## KITTITAS COUNTY DEPARTMENT OF PUBLIC WORKS

### MEMORANDUM

**TO:** All Staff  
**FROM:** Public Works Plan Review Team  
**DATE:** May 29, 2024  
**SUBJECT:** BL-24-00007 Gibson-Scott

RECORD OF SURVEY
A PORTION OF THE N 1/2 OF THE NE 1/4 OF SECTION 26,
TOWNSHIP 18 NORTH, RANGE 17 EAST, W.M.,
KITITAS COUNTY, WASHINGTON

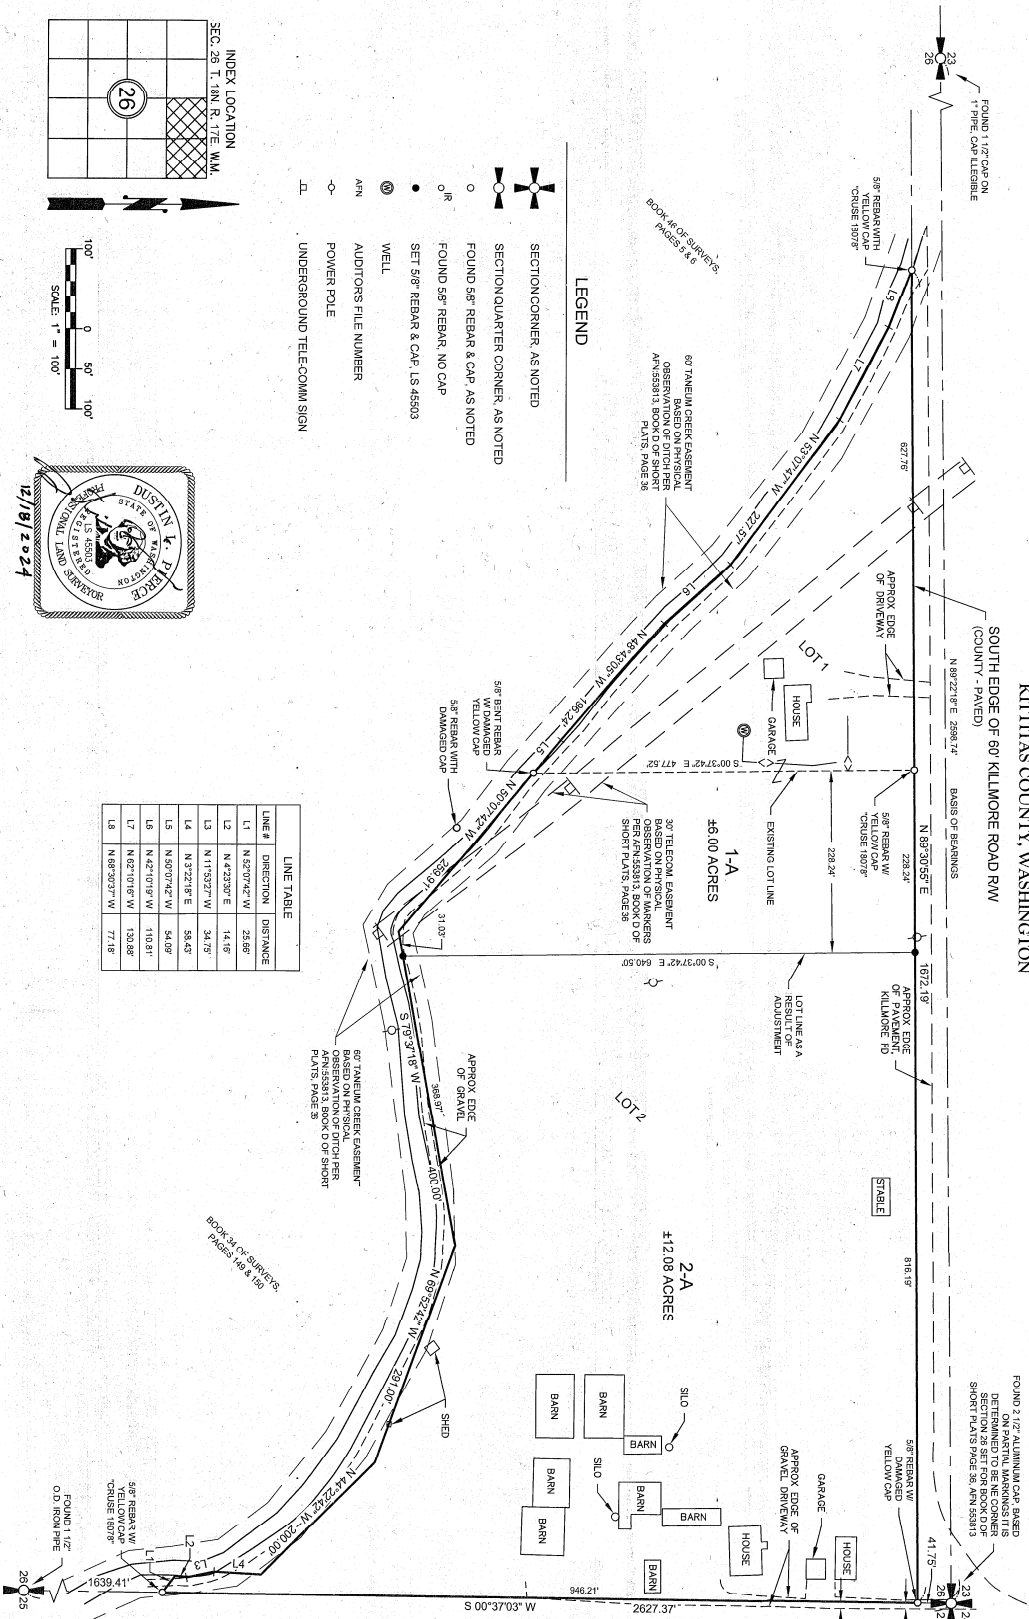
<b>SURVEY</b>	<p>The following map elements will need to be addressed prior to final:</p> <ol style="list-style-type: none"><li>1. Identify Kilmore Rd with ownership (county), surfacing and total R/W width.</li><li>2. Show distances to the usage limits / encroachments along the East boundary of Lot 2 A.</li></ol> <p>OF NOTE Lot closures were not provided or reviewed as part of this application. Given the simplistic nature of the BLA, these are not required. (JT)</p>
<b>TRANSPORTATION CONCURRENCY</b>	No Comments.
